**Consultation Response from KC,
Highways Development Management**
2021/94410 land at, Olney Street, Slaithwaite, Huddersfield, HD7 5EG
Outline application for erection of residential development
**Date Responded: 10-01-
2021**
**Responding Officer: Mark
Berry**
Responding Ref: 1-43-2

This application seeks outline approval to the erection of residential development at land at, Olney Street, Slaithwaite, Huddersfield.

Site Plan 1:500

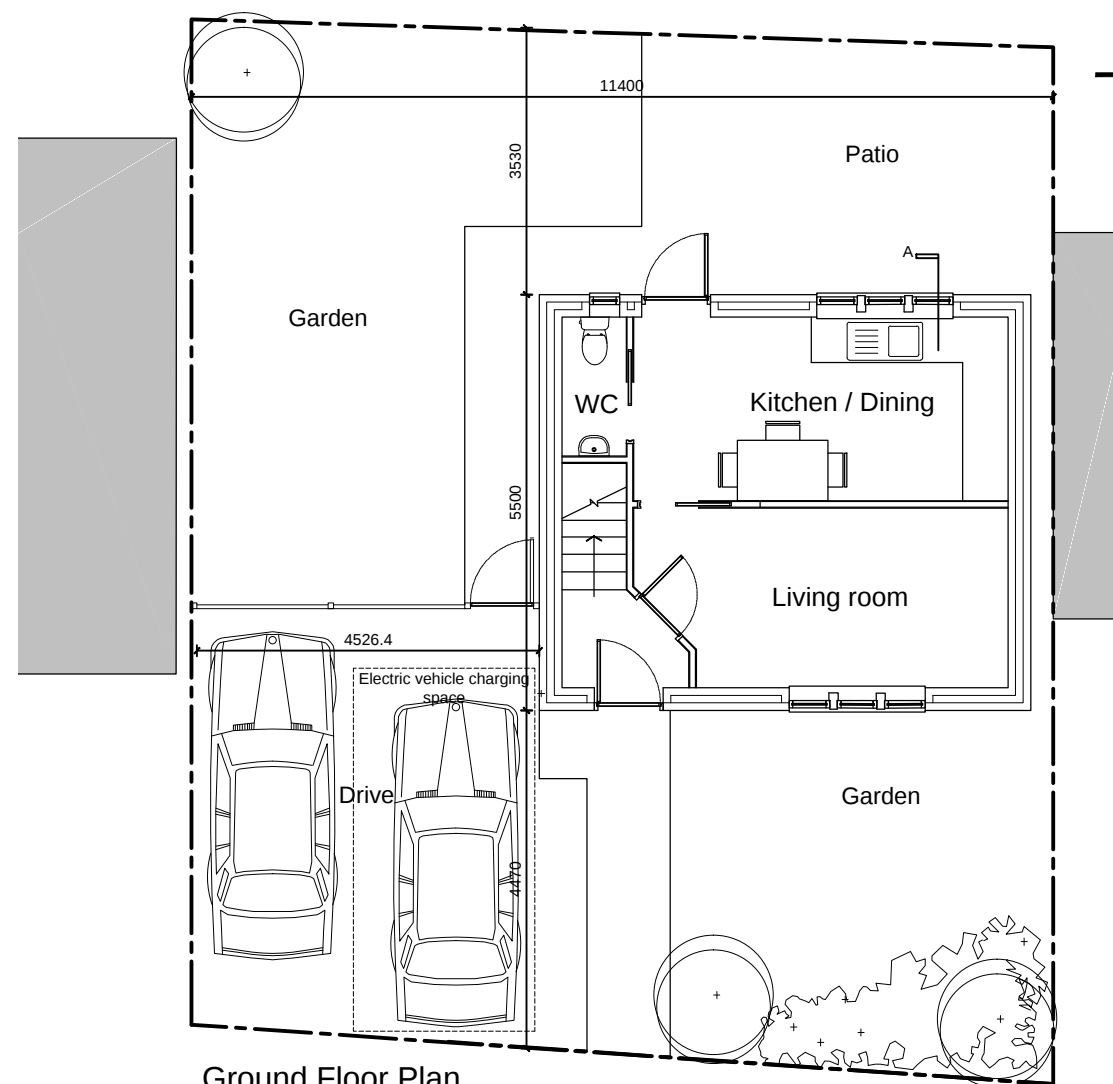
- 1, There is no kerbed footway to the site frontage and a 2.0m wide footway should therefore be shown to be provided.
- 2, The size of the parking spaces is too small at to 4.526 in width and 4.470m in depth. Parking spaces should be 3.2 m in width x 5.0m in length.
- 3, Bin collection points should be provided to enable bins to be presented on collection day without either obstructing the highway or proposed driveway.
